**Application no: 23/02219/DISC**

**Location:** Land North And Adjoining Home Farm, Banbury Road B4100, Caversfield

## **Transport Development Control**

No objection to discharge of condition 10 - phasing plan

Phasing Plan

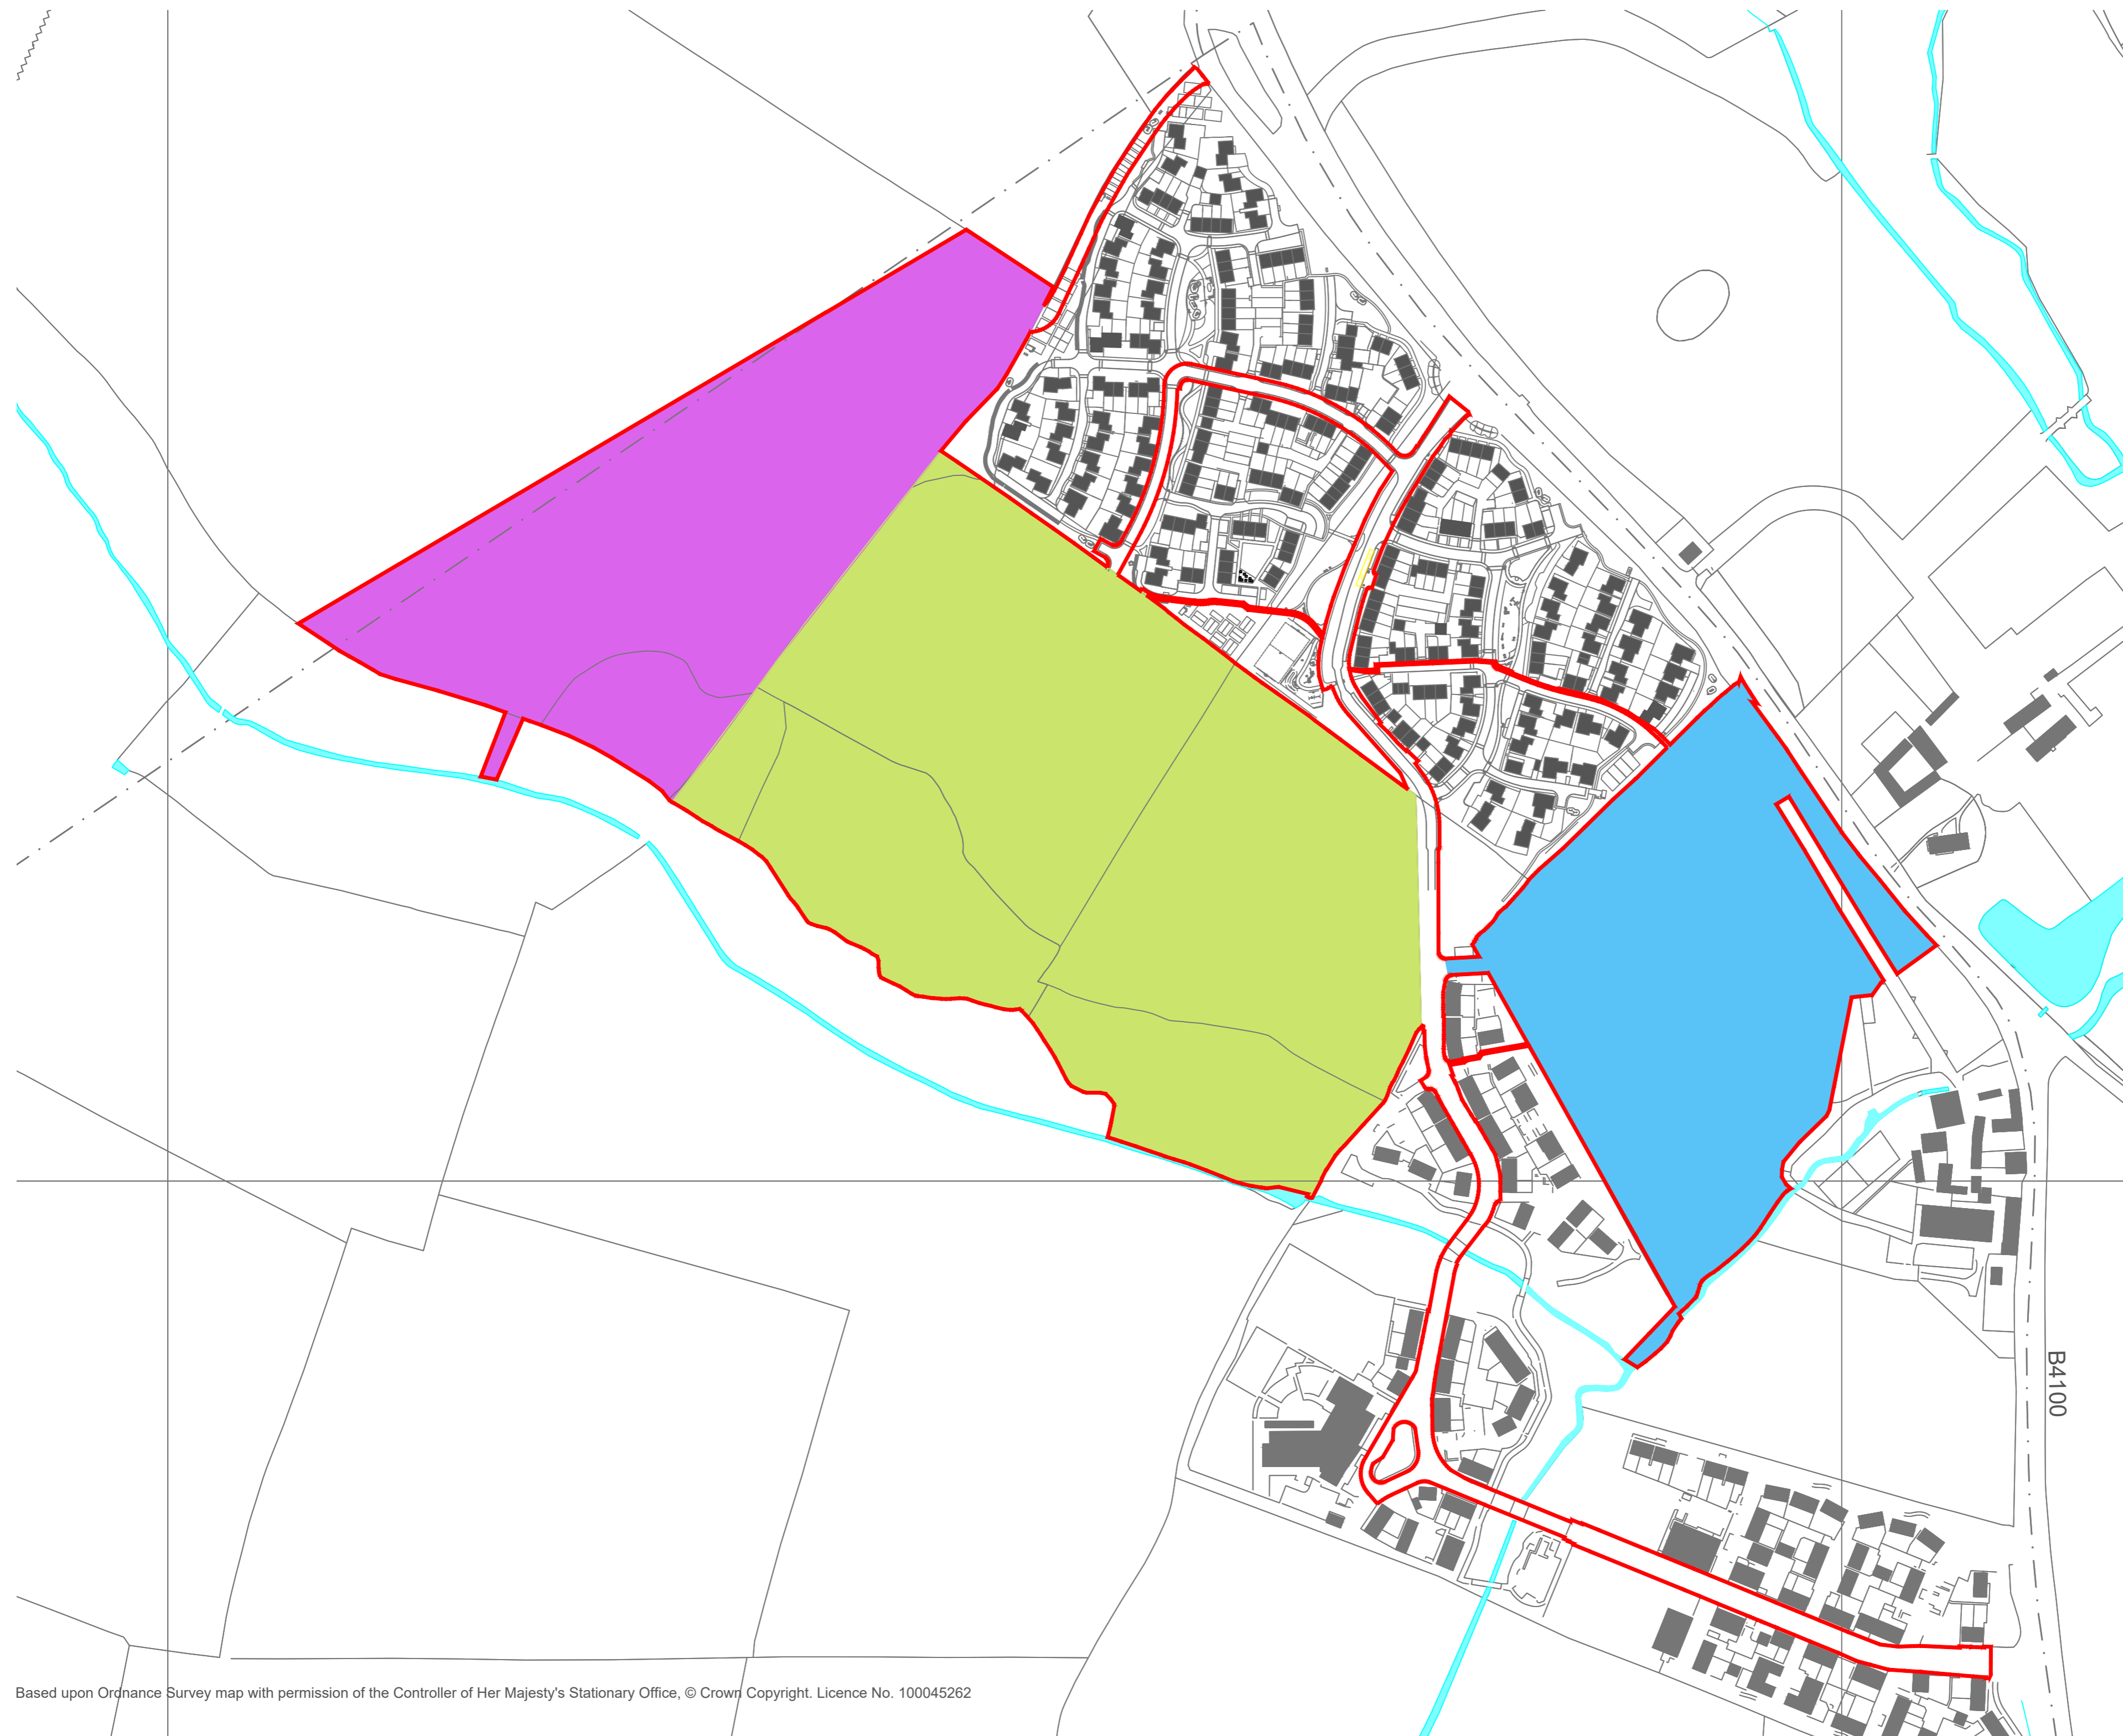
This is a very high level plan, just dividing the site up into three areas, and not specifying any order in which they will be built out. Infrastructure is not shown separately. However, highways triggers relating to construction and permanent accesses are set out in conditions/obligations, therefore the lack of detail on the phasing plan is not, I believe, an issue for highways.
